## MEMORANDUM

**TO:** Jean Fraser, Planner  
**FROM:** David Senus, P.E. & Ashley Auger, E.I.T.  
**DATE:** May 15, 2014  
**RE:** 421 Warren Avenue, Final Level III Site Plan Application

Woodard & Curran has reviewed the Final Level III Site Plan Application for the proposed 6-unit commercial complex located at 421 Warren Avenue in Portland, Maine. The project consists of constructing a single-level 25,000 SF industrial building along with associated site improvements, which will result in approximately 56,252 SF of new impervious area. The project is being reviewed for compliance with City of Portland Level III Site Plan requirements and under the City's delegated review authority for Chapter 500, Stormwater Management Law.

**TO:** Jean Fraser, Planner  
**FROM:** David Senus, P.E. & Ashley Auger, E.I.T.  
**DATE:** March 3, 2014  
**RE:** 421 Warren Avenue, Preliminary Level III Site Plan Application

SEE SCHEDULE B

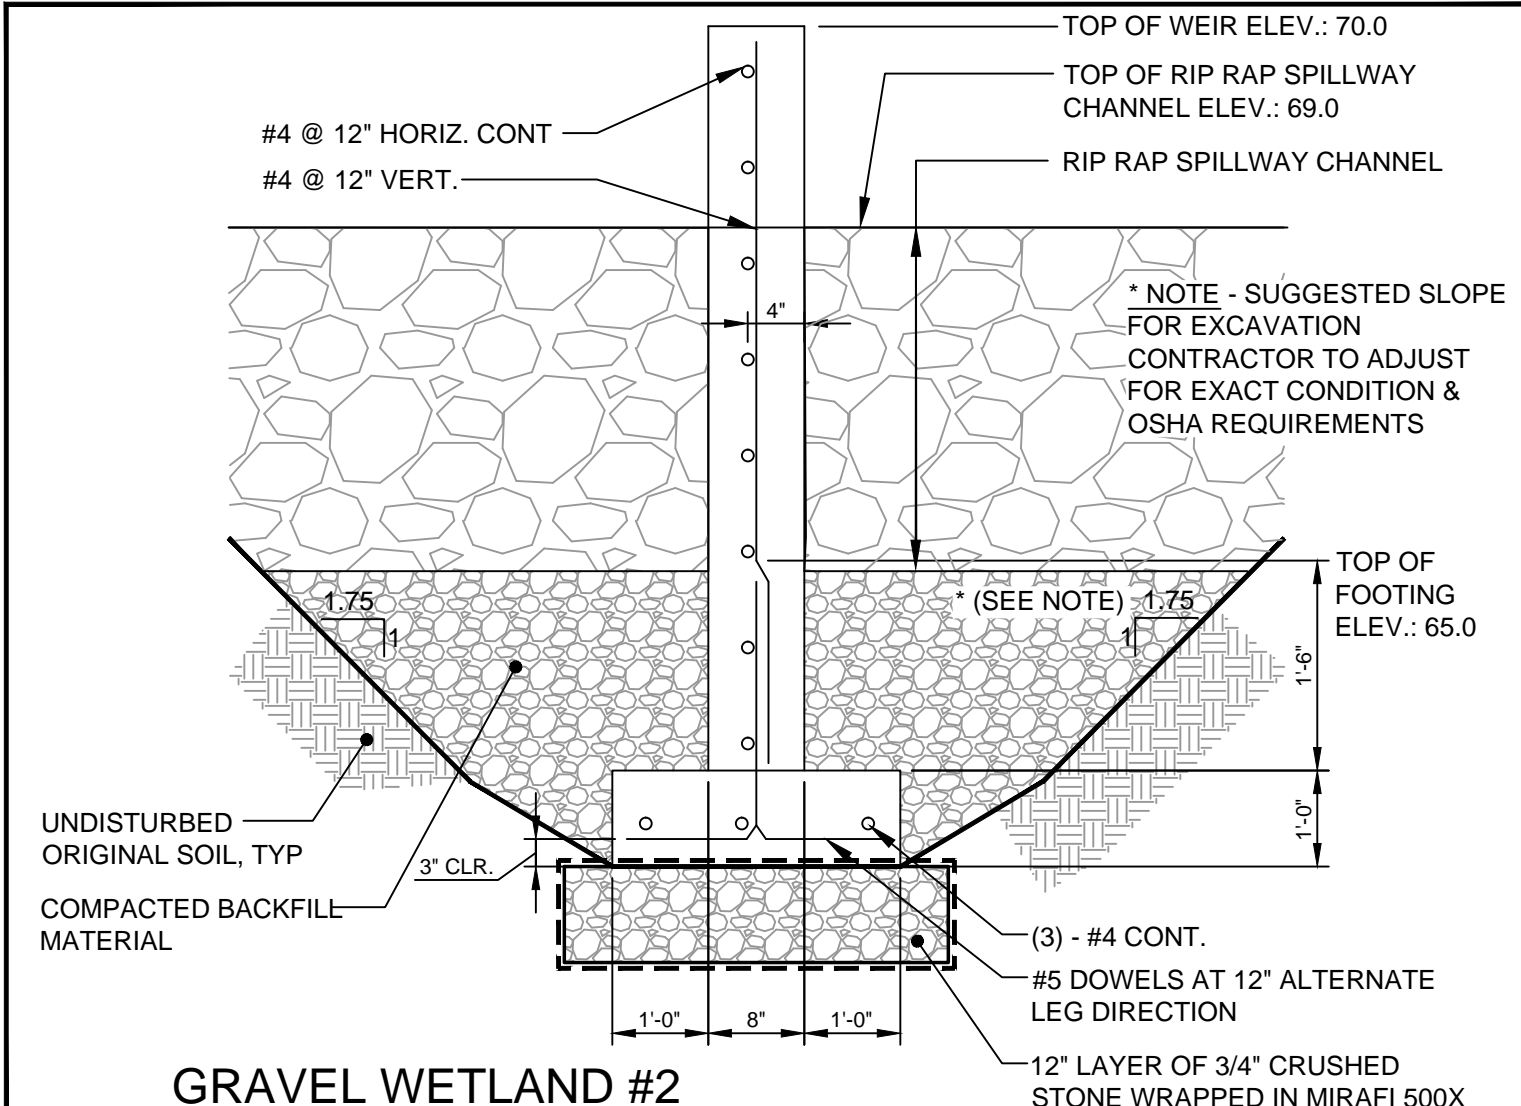
- e) As noted on the plans, the Applicant intends to add outlet elevation information to the outlet control structure details for both gravel wetlands as part of the final submittal. Without this information we cannot verify the routing or model inputs for Pond 4P (GW2) or Pond 5P (GW1). When the outlet control structure elevations are incorporated into the final submittal, please revisit or provide explanation on the routing methodology for GW1 & GW2 in the HydroCAD model; we are unable to follow the routing as currently presented.

- b) The Applicant has submitted drawdown calculations for sizing the gravel wetlands' outlet control structure orifice control devices; however, the orifices do not appear to be specified on the design plans/details. The Applicant should clarify with the final design package.
